Pathways Cremorne Seniors Housing

Application No: SSD-49472213

Location: 50-88 Parraween Street, 59-67 Gerard Street, Cremorne 2090

Brightmore Precinct **STRONGLY OPPOSES** the Pathways Cremorne Seniors Housing Development, which falls within our precinct in North Sydney LGA.

BASEMENT PLAN

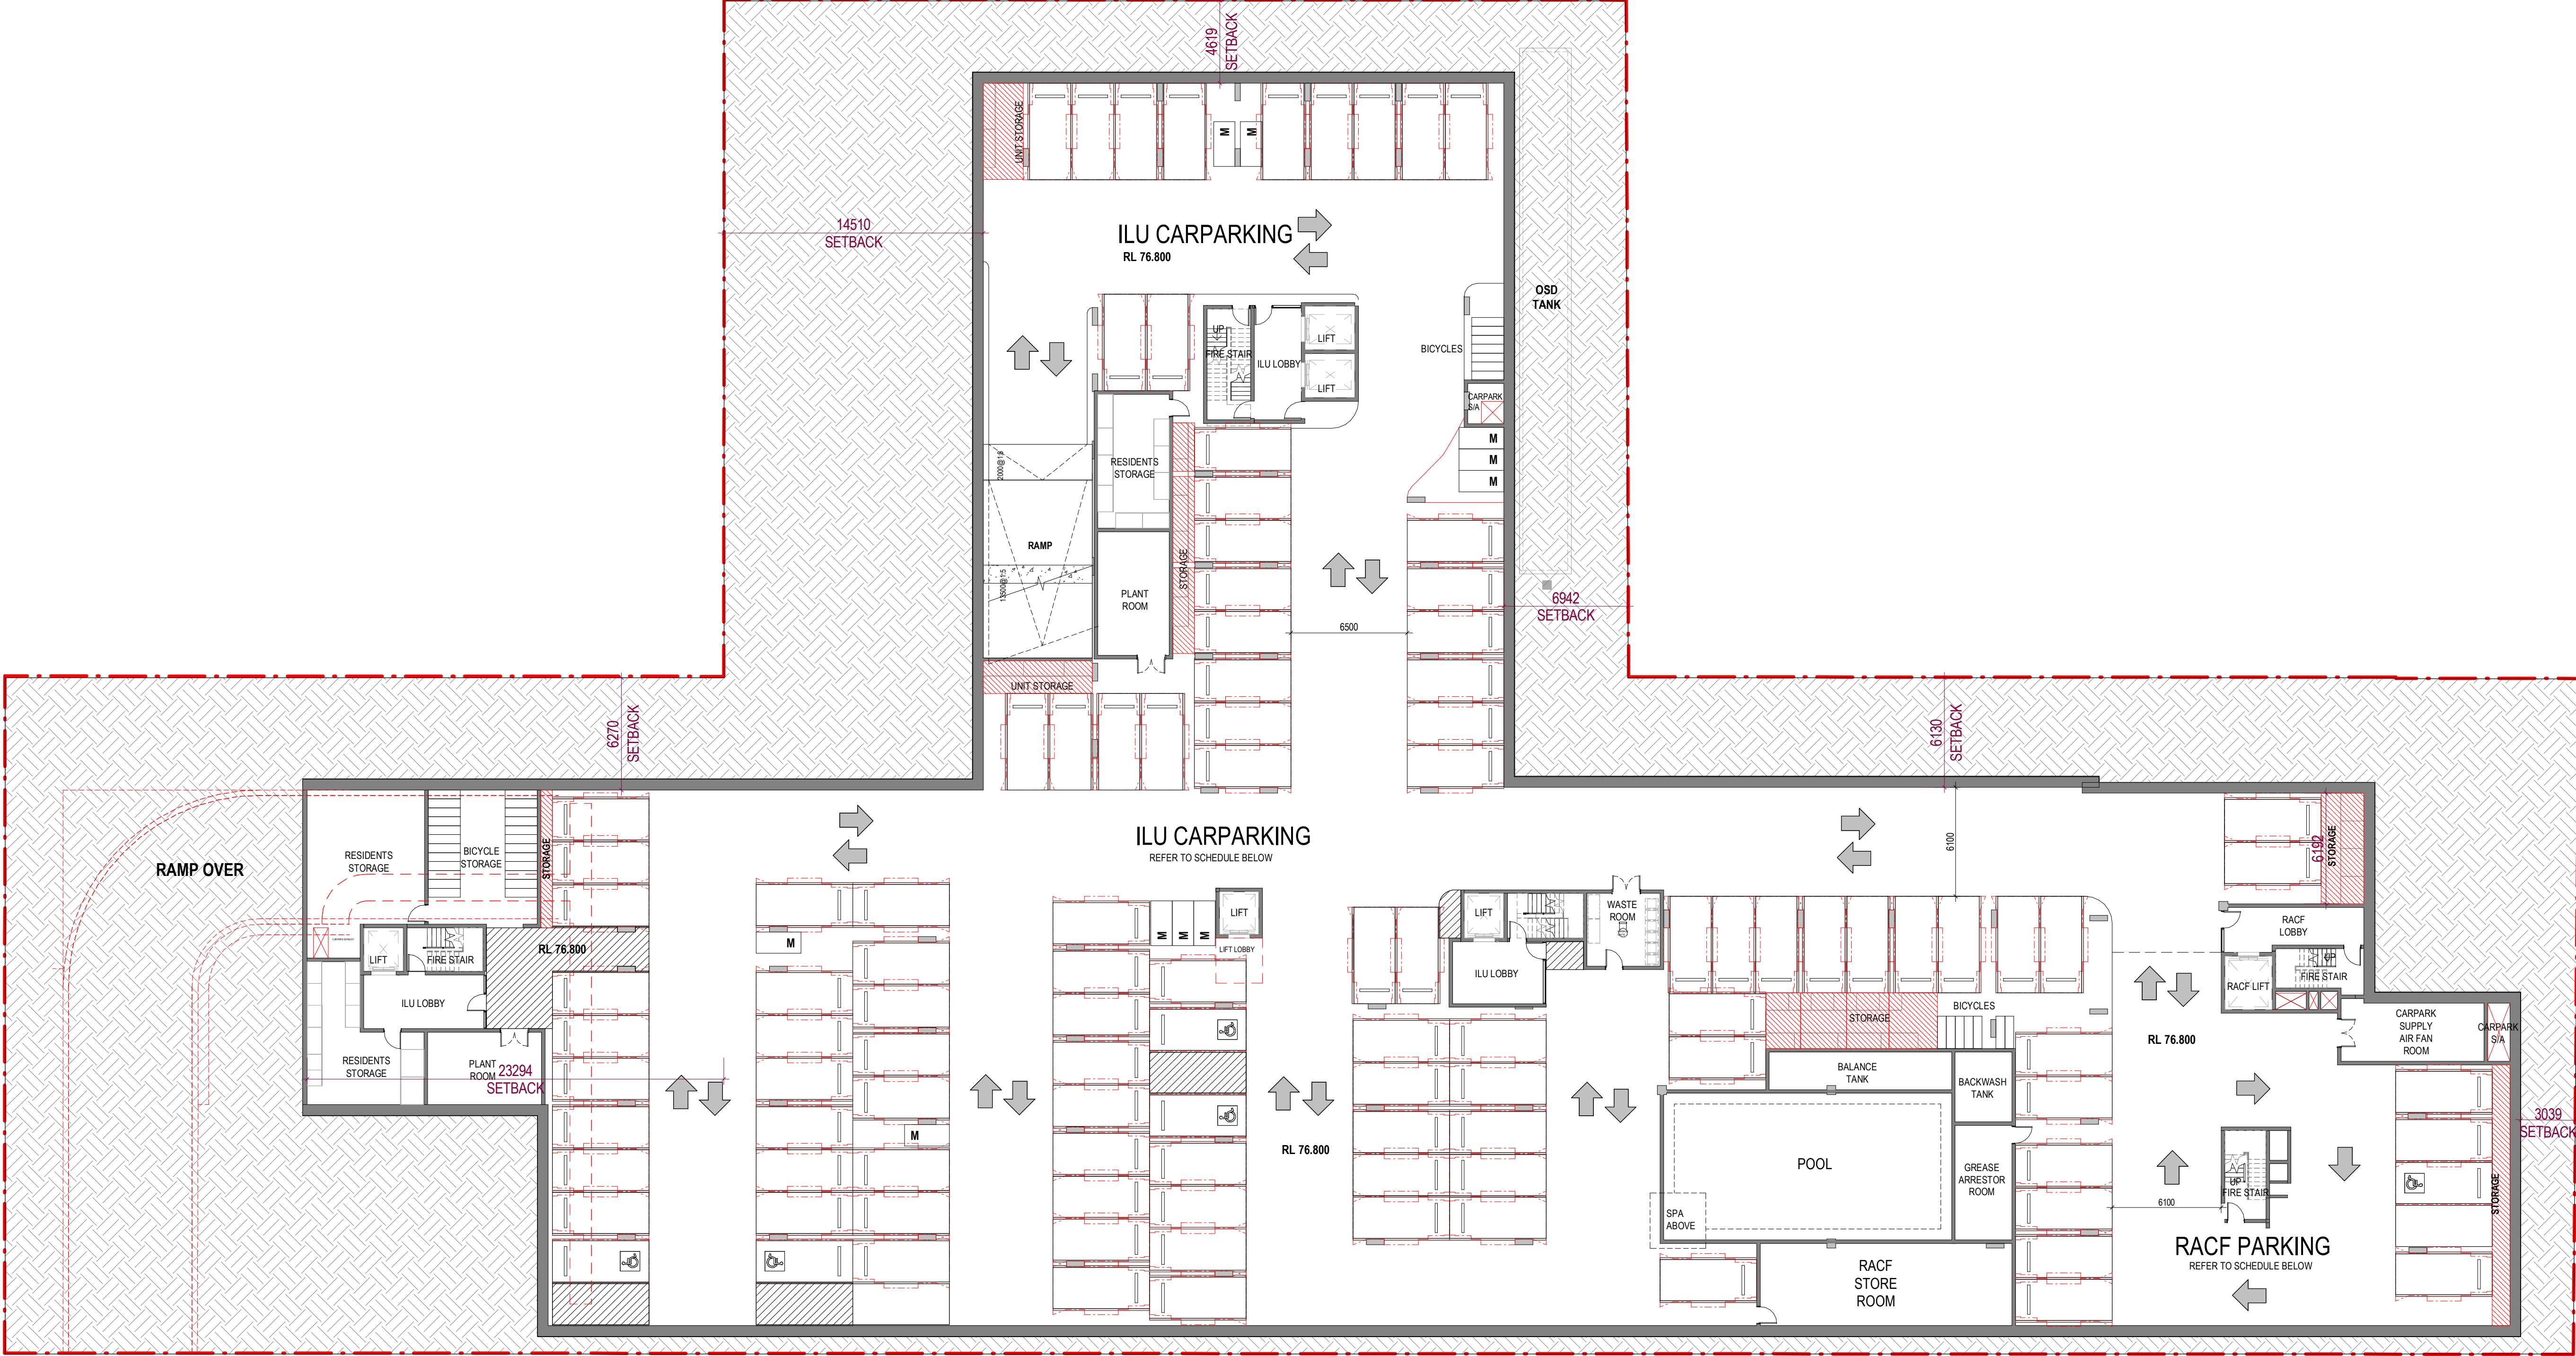
Extra traffic will be generated by vehicles not only from the facility's carpark (134 car spaces, 56 bicycles and 9 motor bikes), but also from daily service vehicles for waste collection, goods & food delivery, ambulances etc.).

All vehicles have to use a single driveway to enter and exit the underground carpark, which will lead to congestion at this point.

The underground carpark for 134 cars, 56 bicycles and 9 motor bikes will be serviced by a single driveway (entry & exit) on Parraween St. Are any of these carspaces reserved for visitors or staff? Or do they park on the street, compounding the parking problem for residents and other users of Cremorne village? The Hayden Orpheum Picture Palace in particular creates a strong demand for parking, as do the restaurants in Cremorne Plaza.

1 NORTH WEST ELEVATION
(GERARD STREET)

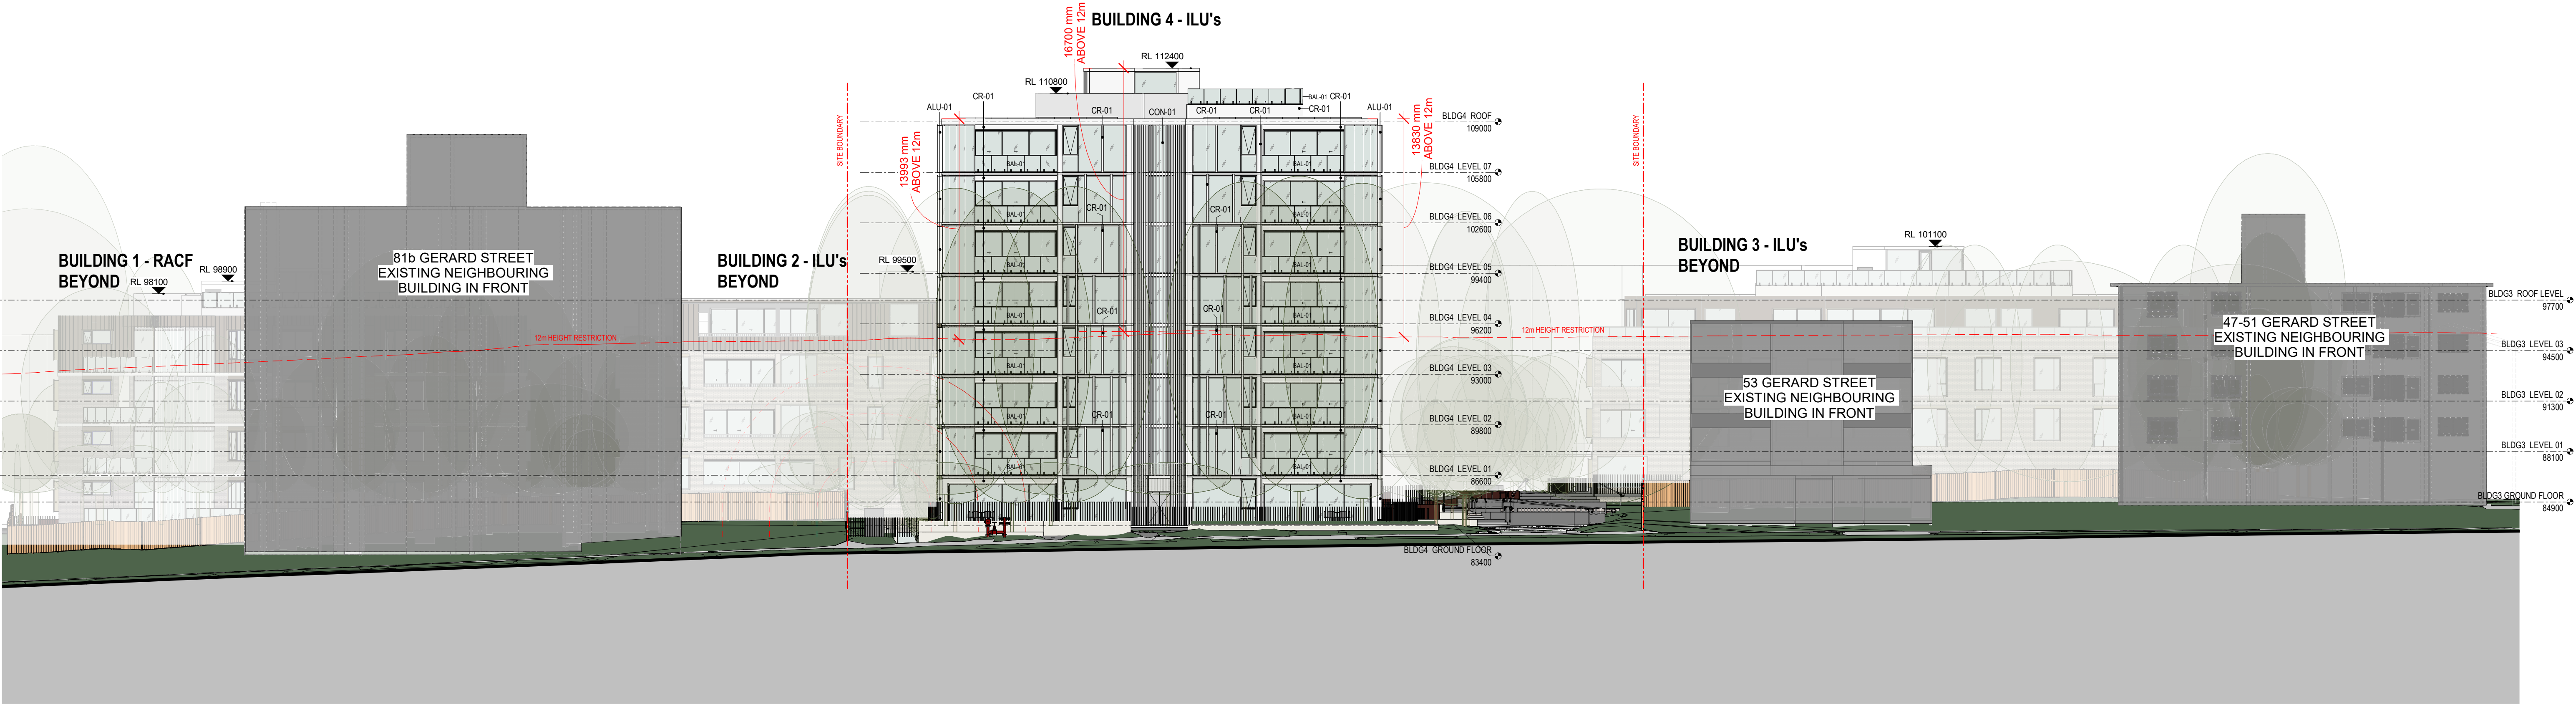
The 8-storey building proposed for Gerard St is 28.66 metres, which is more than double the zoning of up to 12 metres.

The cumulative effect of the 4 buildings - 1 x 8-storeys, 1 x 5-storeys and 2 x 4-storeys, will dominate Parraween St. This is a massive overdevelopment of the site, and not within the planning controls.
